Reference: #13S1213000

09 February 2016

**RE: 1 CARRINGTON STREET, SYDNEY**  
**TRANSPORT ASSESSMENT REVIEW FOR SECTION 96 APPLICATION**

Transport for NSW (TfNSW) has requested additional information regarding the Section 96 application lodged for the approved development at 1 Carrington Street, Sydney.

DRAWINGS  
L-000 COVER SHEET  
L-100 PUBLIC DOMAIN CONCEPT PLAN  
L-110 PUBLIC DOMAIN MATERIALS

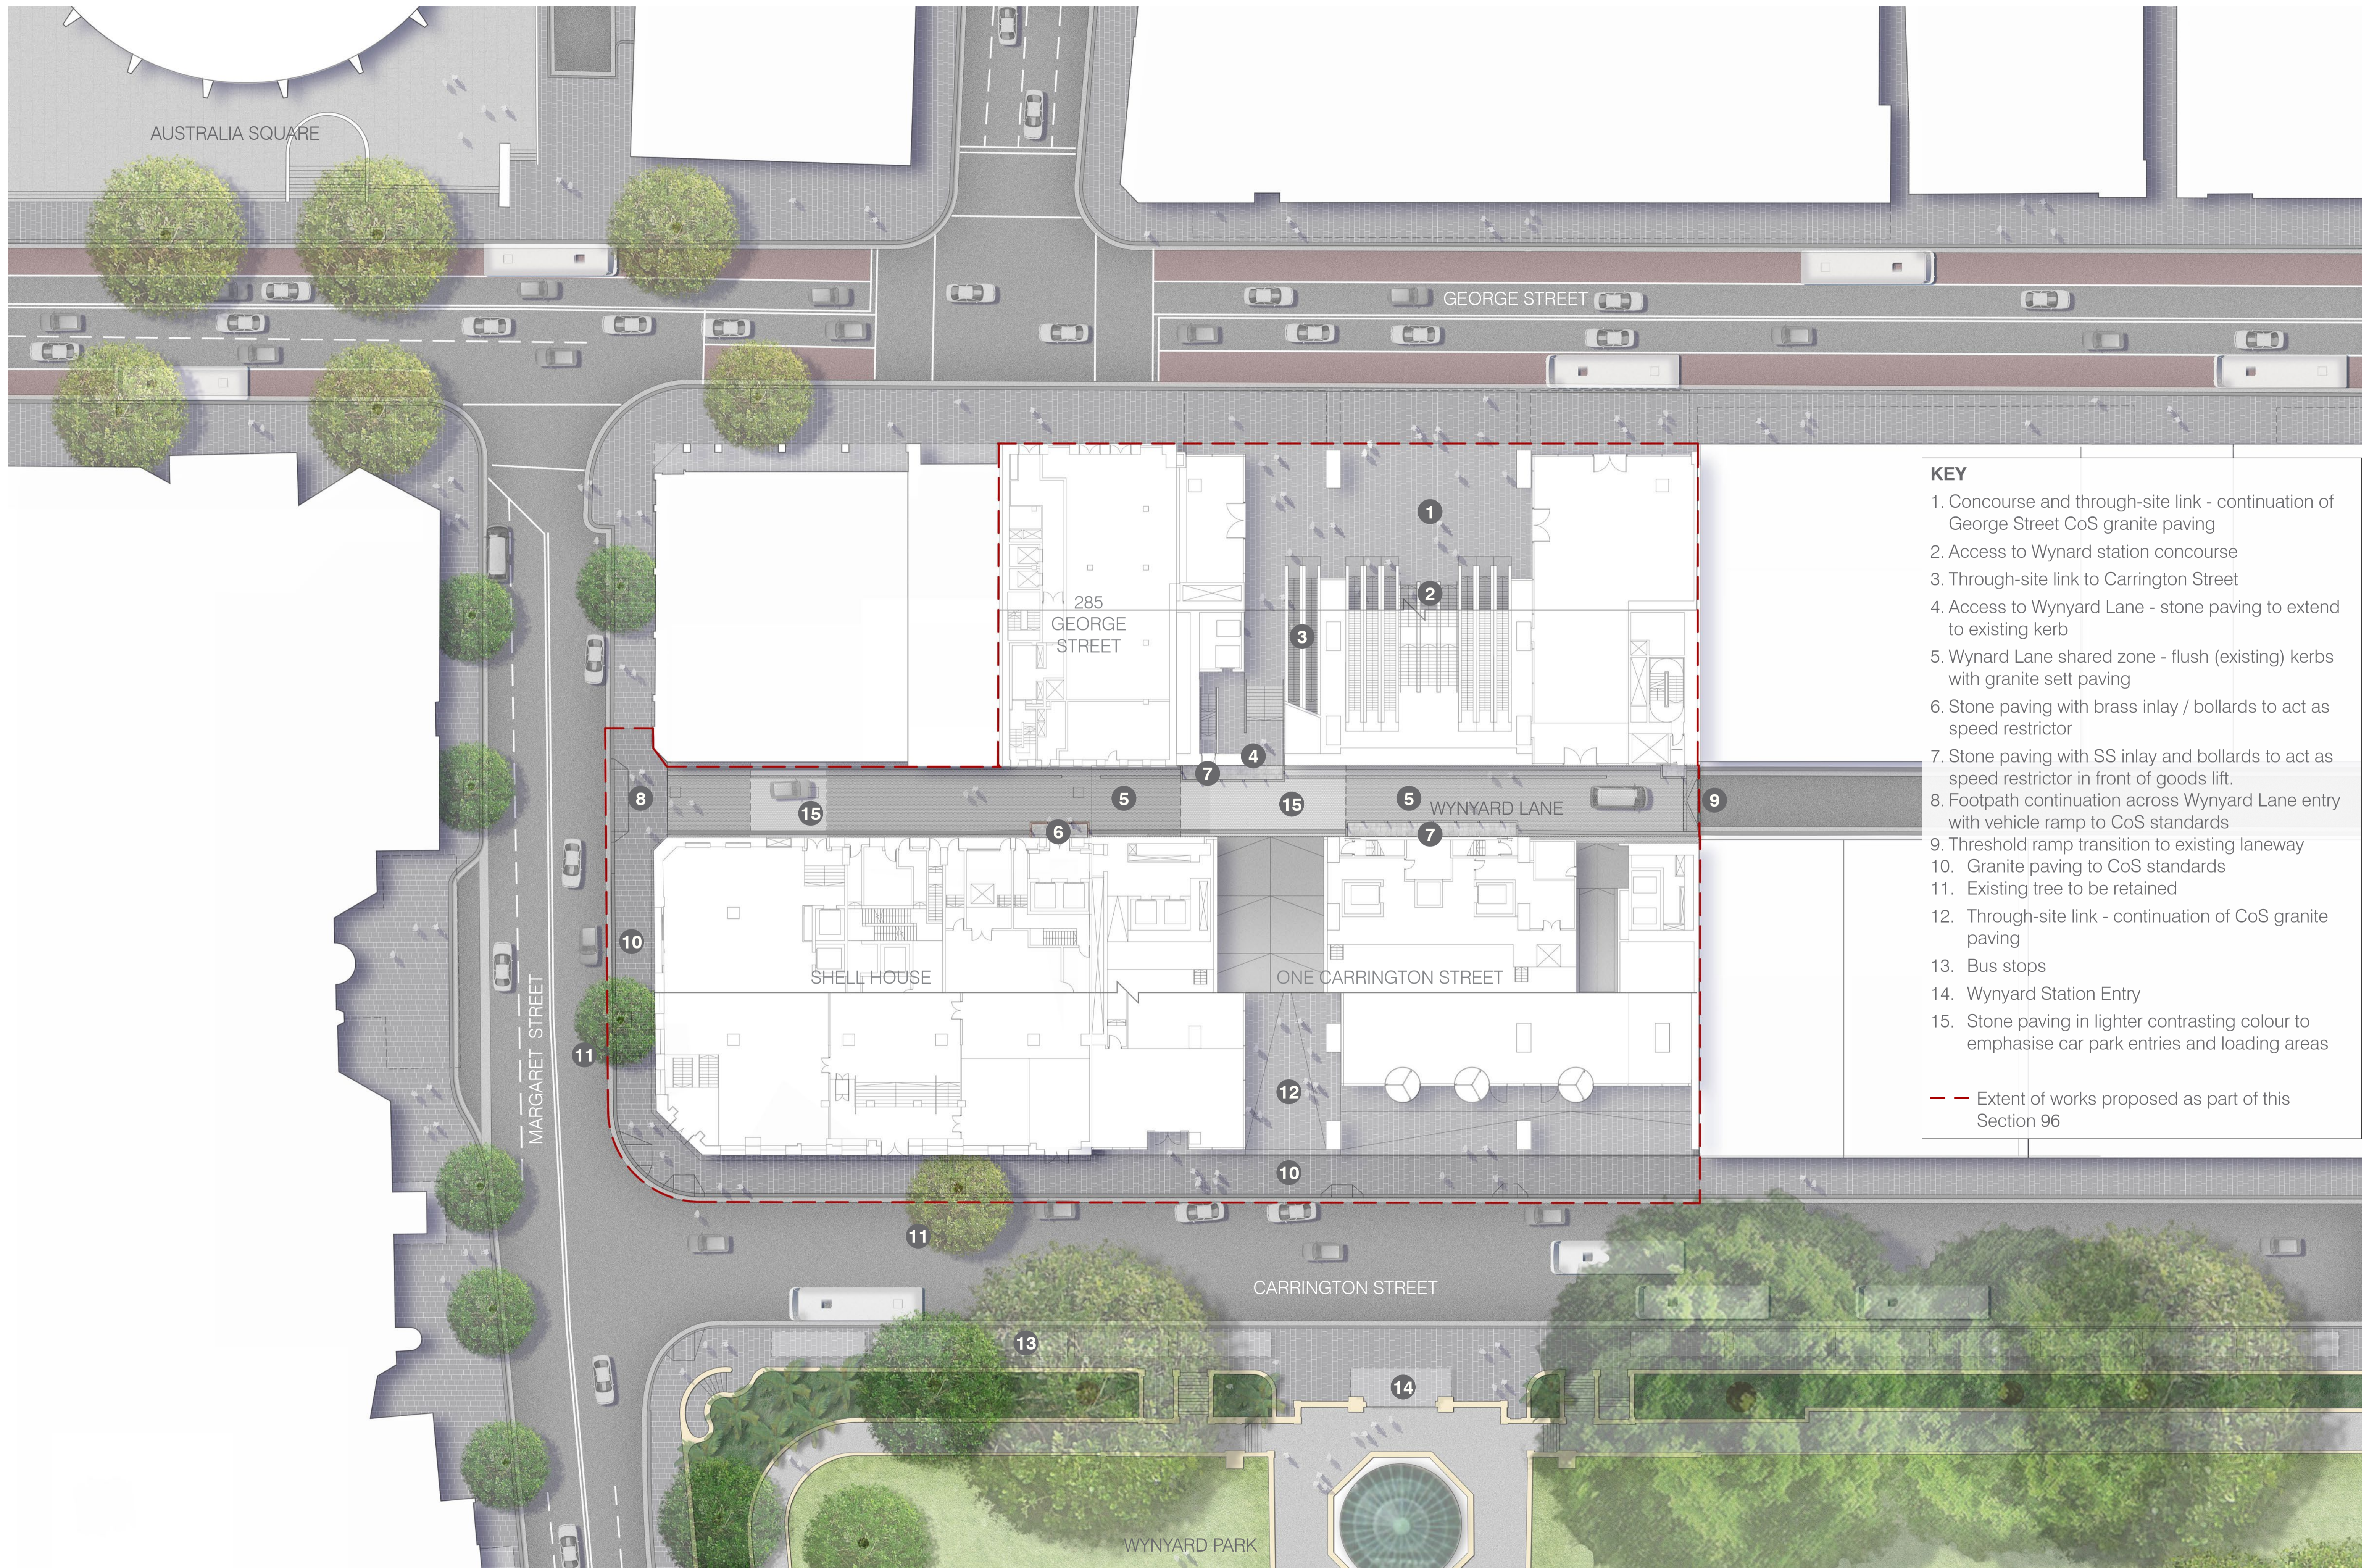
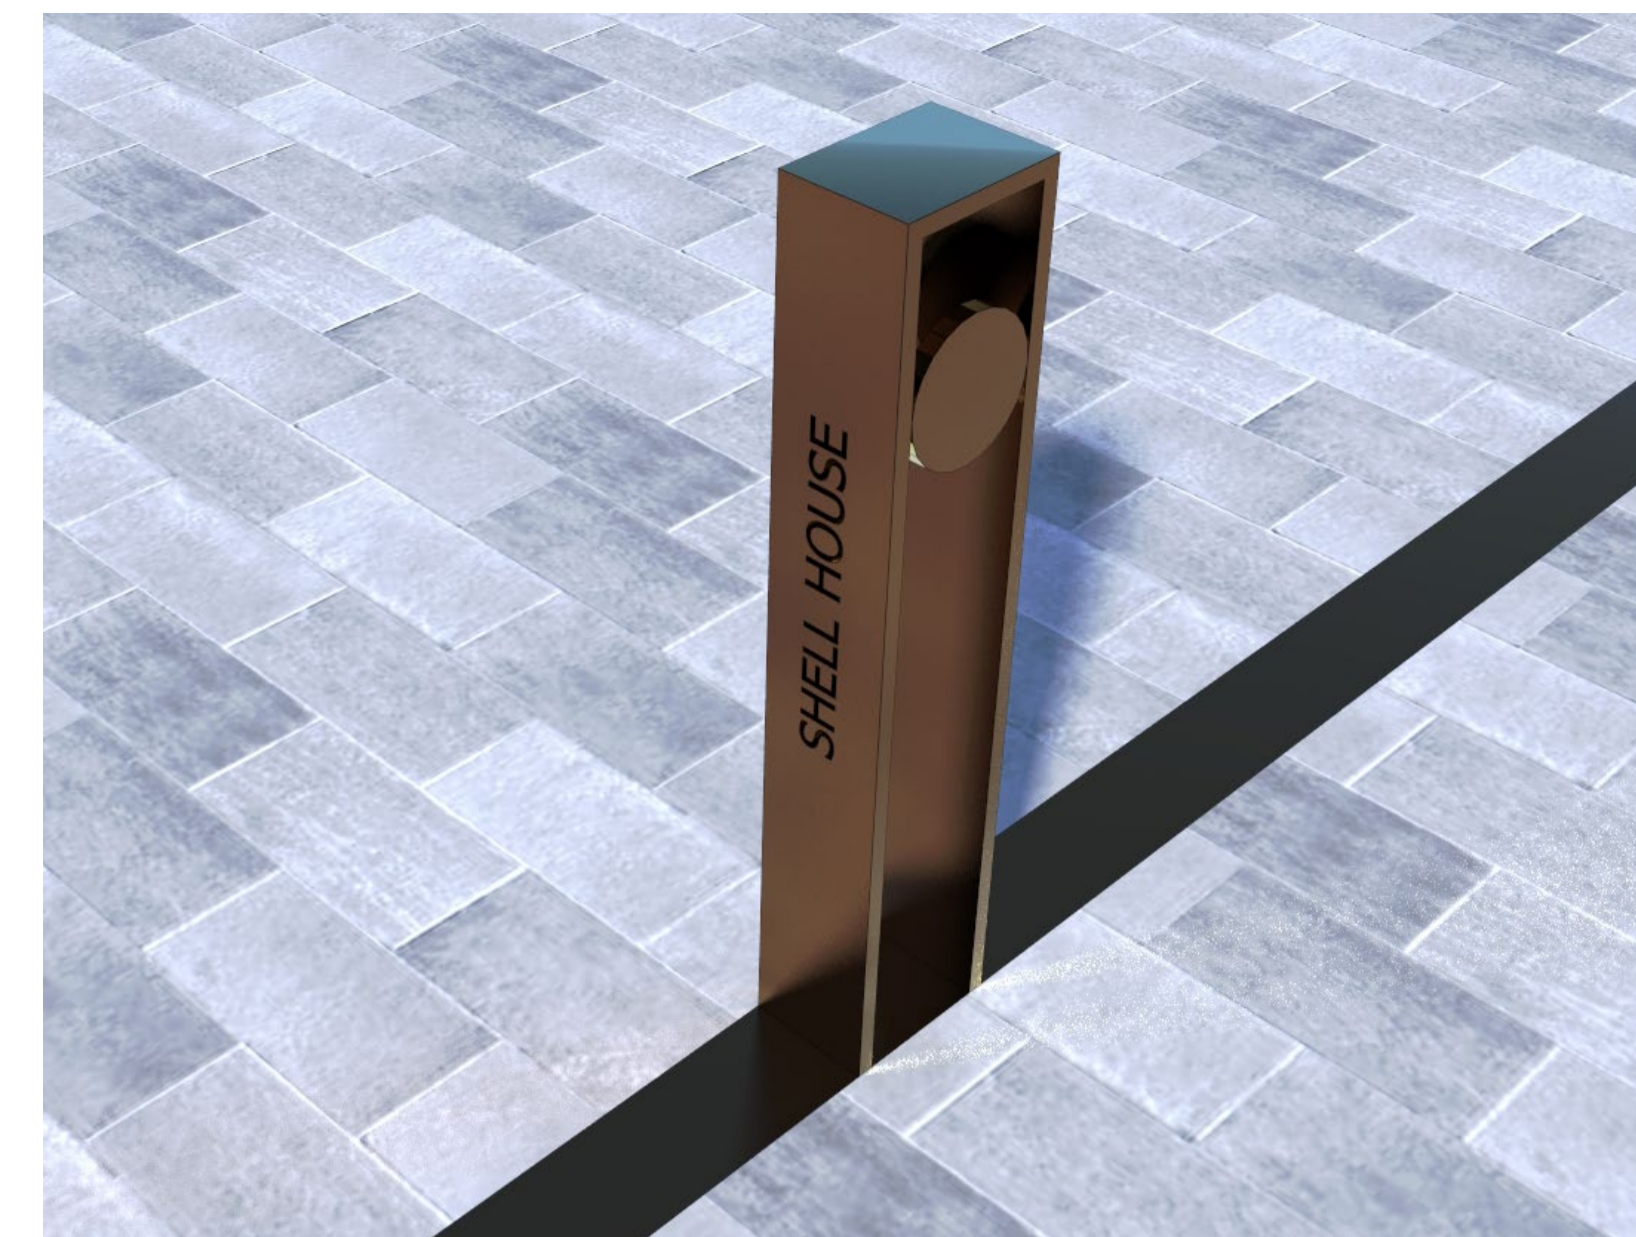
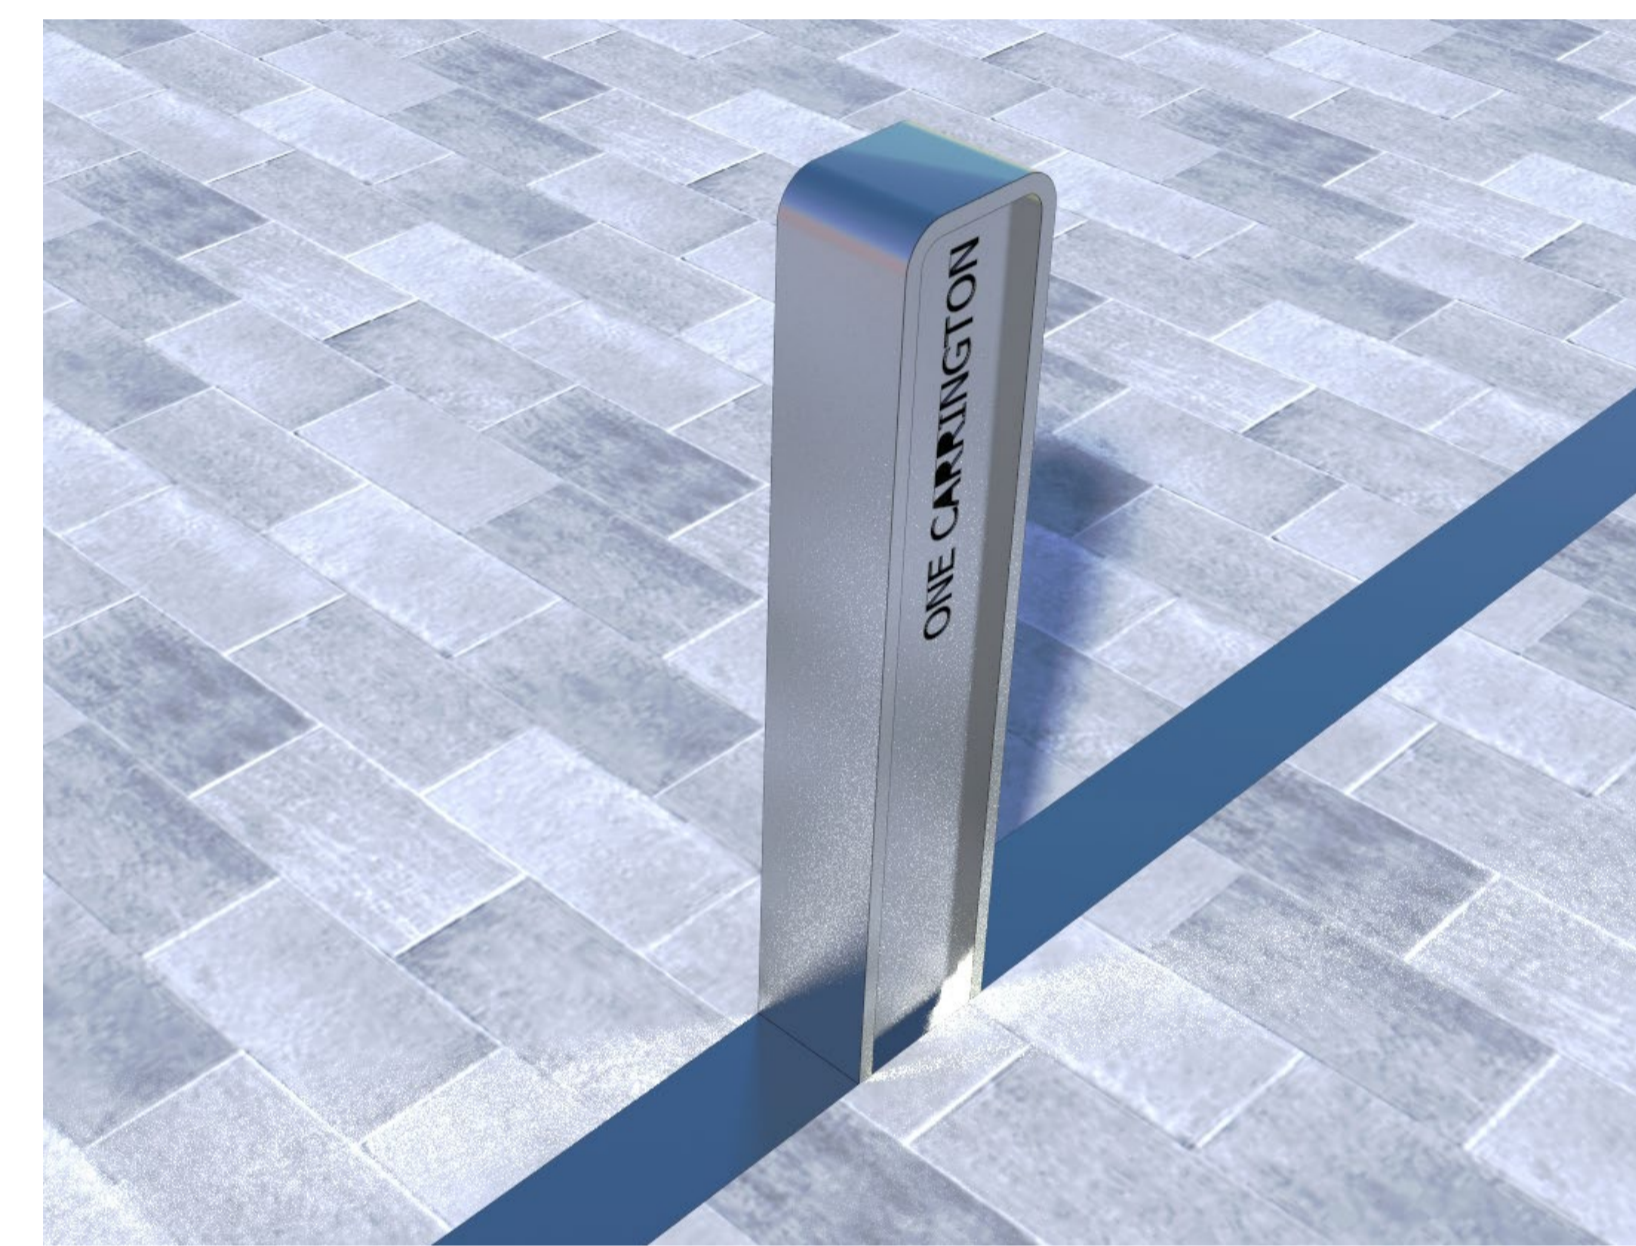
- "Proposed Stone Paving with Brass Inlay/Bollards
  - The Public Domain Concept Plan (PDCP) prepared as part of the modification proposal includes stone paving with brass inlay/bollards to act as a speed restrictor. The proposed arrangement is not supported by TfNSW due to the following reasons:

- The proposed arrangement would guide vehicles to travel along the eastern side of Wynyard Lane. As a result of this, pedestrians entering Wynyard Lane opposite to the applicant's car park access from the east would step into the path of oncoming vehicles. Therefore, there is a potential conflict between pedestrians entering Wynyard Lane and the vehicles travelling along Wynyard Lane.

- The proposed stone paving with brass inlay/bollards area located south of Margaret Street on Wynyard Lane may have the potential to restrict the turning path of the vehicles accessing the loading bay for the proposed development at 275-281 George Street.

- Based on the above, TfNSW requests that the applicant demonstrates the proposed stone paving with brass inlay/bollards along Wynyard Lane would not have impact on the proposed development at 275-281 George Street and the pedestrian safety along Wynyard Lane."

- "Proposed Pedestrian Entry to Wynyard Lane
  - The PDCP shows that pedestrians enter Wynyard Lane from the east opposite the car park access for the proposed development where multiple vehicle movements will occur.
  - This arrangement would have the potential to cause pedestrian/vehicle conflicts and is likely to increase pedestrian related incidents at this location. TfNSW requests that the applicant demonstrates the proposed arrangements at the car park access would not cause pedestrian related incidents."

- "Access to Public Car Park
  - *The PDCP shows a narrow car park entry and a ramp to the public car park. It should be noted that the public car park access needs to include the vehicle entry lane as well as a pedestrian path. This would enable public to access the car park. It is not clear from the documentation prepared as part of the modification proposal whether the proposed public car park entry accommodates vehicle as well as pedestrian movements. TfNSW requests that the applicant demonstrates the width and gradient of the car park entry cater for vehicles as well as pedestrians in accordance with relevant standards."*

The proposed Shared Zone design has been revised to provide a central trafficable lane width of 3.5m with 1.3m wide (approx.) brass inlay/bollard areas along both eastern and western sides of the laneway. This concept is shown plans prepared by Oculus, reproduced in 1 and 2.

As mentioned above, the Shared Zone design has been revised to accommodate a central trafficable lane width of 3.5m and brass inlay/bollard areas on both sides, with a width of 1.3m (approx.).

In our professional opinion, this arrangement – together with the formalisation of the laneway as a 'Shared Zone' – can be expected to reduce the potential for vehicle and pedestrian conflicts at this location, whilst still accommodating necessary swept path requirements into and out of the main vehicle site access.

*"Access to the public car park will remain via the existing public entry and ticketing point located at Coles supermarket level within Wynyard Station. This provides direct access to Carrington Street and York Street, Wynyard Park and Concourse Level from the car park.*

*With the introduction of the new through site link from Carrington Street to George Street and improved vertical transport connection within the Wynyard Place development to the Concourse Levels the need to enter from Wynyard Lane is removed. Therefore no pedestrian access will be provided from Wynyard Lane to the existing public car park. This will improve safety and remove any potential conflict between pedestrians and vehicles."*

In addition, GTA also notes that public car park ramp, which is restricted to entry vehicle movements only, has been designed in accordance with AS/NZS890.1. Specifically, the ramp features a wall-to-wall width of 3.6m, including 0.3m clearances, compliant ramp grades which include a 1:16 transition at its top and a 1:8 maximum grade, and a height clearance of 2.5m.
